From: Jones, Janet <Janet.Jones@enwl.co.uk>
Sent: 03 March 2016 14:21
To: planning
Subject: Your Reference 3/2016/0069 (Contact Stephen Kilmartin) Our Reference PA2617

7 Accrington Road, Whalley, BB7 9TD

Site Plan
Scale: 1:500

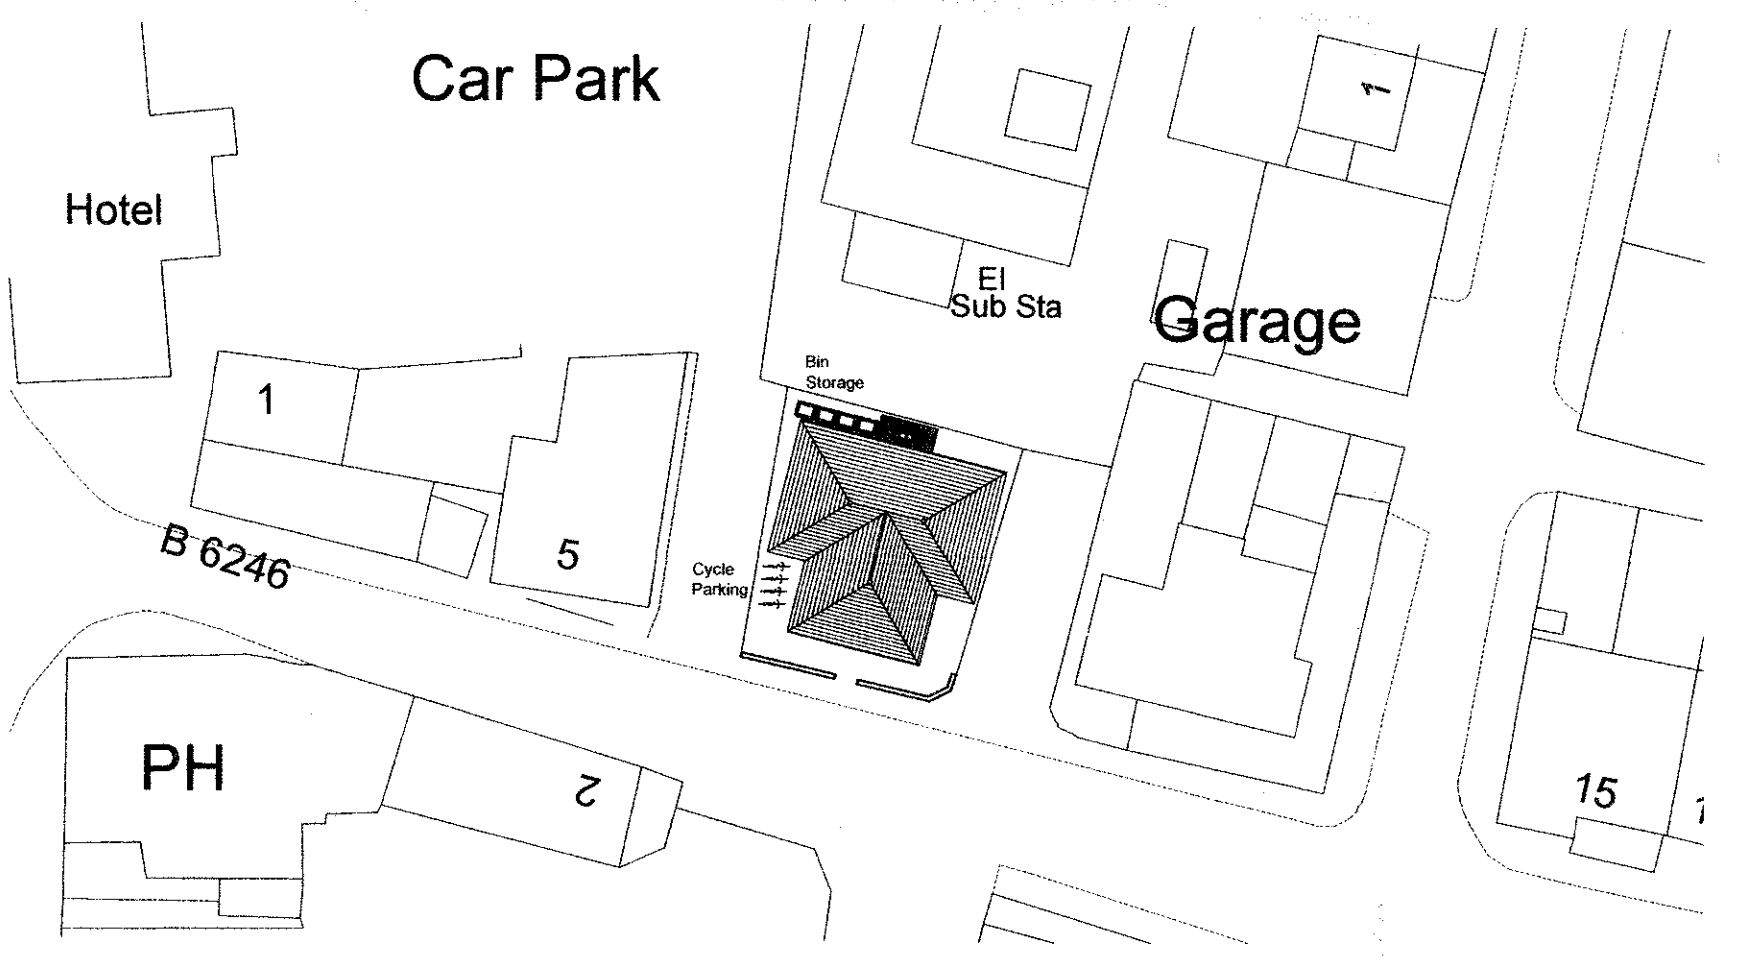
- The existing building has a single phase Low Voltage service which will have to be disconnected before work on site commences.
- To the rear of the proposed development is ENW Substation 33/11kV Whalley Primary (400074). Numerous 33kV and 11kV and Low voltage cables pass on either side of the development. Records indicate that these should be outside the development but with significant works on site proposed, extreme care must be taken during all excavations. All excavations on site must be carried out in accordance with HSE guidance HS(G)47 – Avoiding danger from underground services.

- Additionally, ENW access to Whalley Primary Substation is via a track to the right hand side of the development. It is essential that 24 hour vehicular access is maintained to this site at all times during the development. A proposed vehicular parking space for the development also appears to make use of this access track and the developer is advised to contact ENW Estate and Wayleaves Department at Preston to discuss this before proceeding.
